15 September 2020

Pete Styles – President & Promoter
Australian Lightning Sprints Association (ALSA)
2 Charlotte Crescent
Albion Park NSW 2527

REF: SSI- 10048 – Sydney International Speedway

Detailed Feedback - Issues & Opportunities

Figure 1-3 Project overview

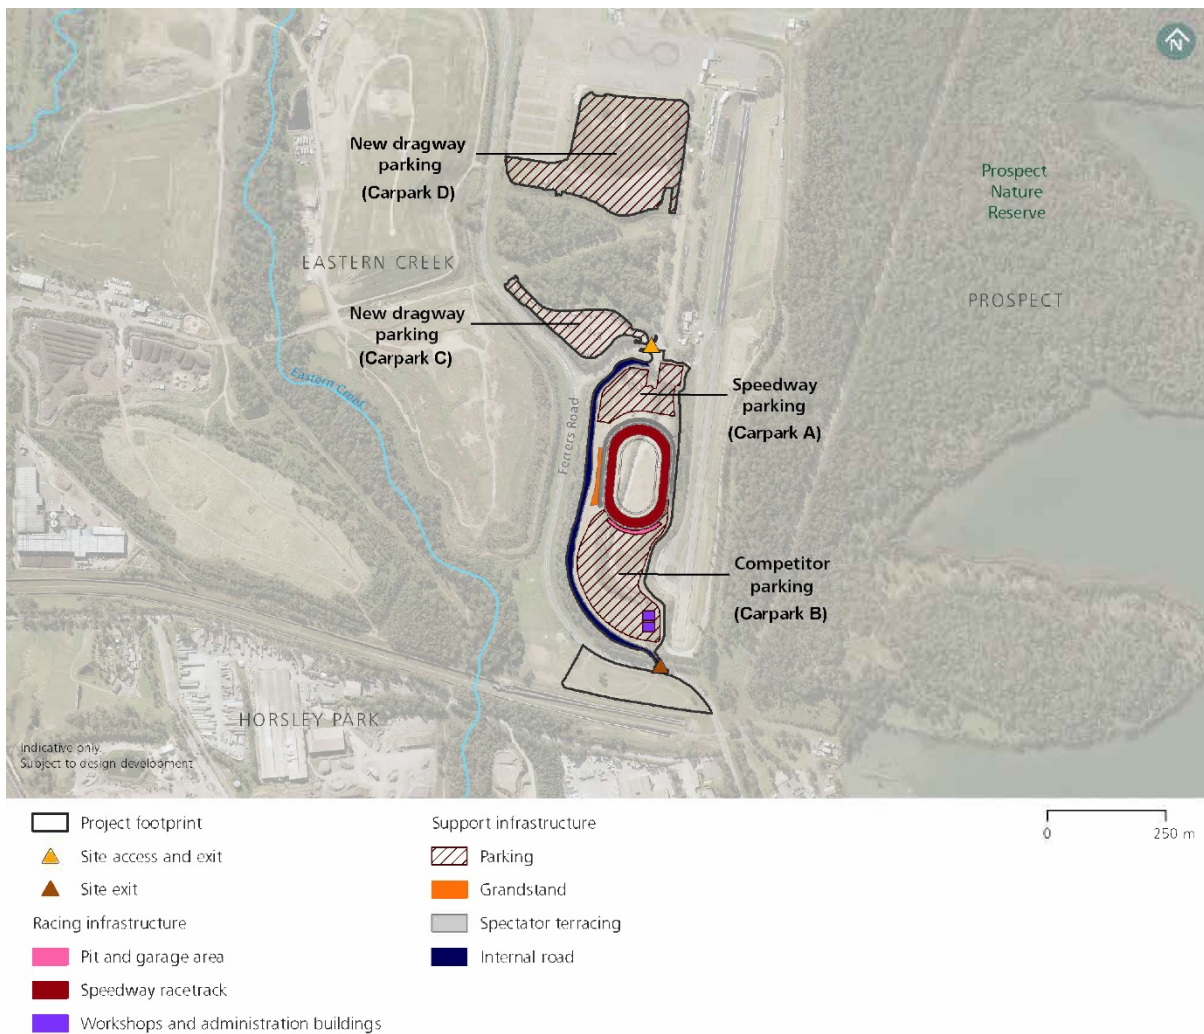
We are concerned that the overall capacity of the venue falls short of requirements. The seated capacity described by the EIS identifies only 3750 seated capacity within the grandstand supported by terrace seating and corporate boxes to reach 7,000 (EIS Section 1.4 pg3 & Table 5-3 pg 47).

The 7,000 spectator capacity, the immediate parking for 600 spaces and the overflow 460 space drag way parking in section C (Section 5.3.1 Pg45) would generally be sufficient for the regular lower attended weekly events run at the new venue but would fall short during peak season and major events needing to use Section D to full capacity. It is very important to understand Valvoline Raceway patrons currently flood the adjoining streets of the area on any given night, but major events often leave people parking many kilometres away. Valvoline Raceway run a courtesy bus for this reason. The existing VR carpark is not even close to handling our capacity today.

This arrangement severely limits crowd capacity for major events even with support of the extra 1760 spaces in section D. With limitations on open grass space that we currently have available at Valvoline Raceway, this design appears to fall short in terms of the capacity needed for a world class multi-use site.

Based on the urban design visualisation layouts presented, there appears to be an issue with two 90 degree dog leg turns within the 600 space spectator carpark, that would restrict B doubles from negotiating the carpark part of the competitor vehicle access route.

As indicated below by the red line, the route to the competitor pits should be relocated around the main carpark running along the boundary line. This would avoid spectator parking issues and safety issues involving kids and families waiting for the event.

Opportunity 4a: To provide B Double Truck access, avoid spectator parking blockages and safety issues between spectator traffic and competitor haulers, the route to the competitor pits should be relocated around the main carpark running along the boundary line.
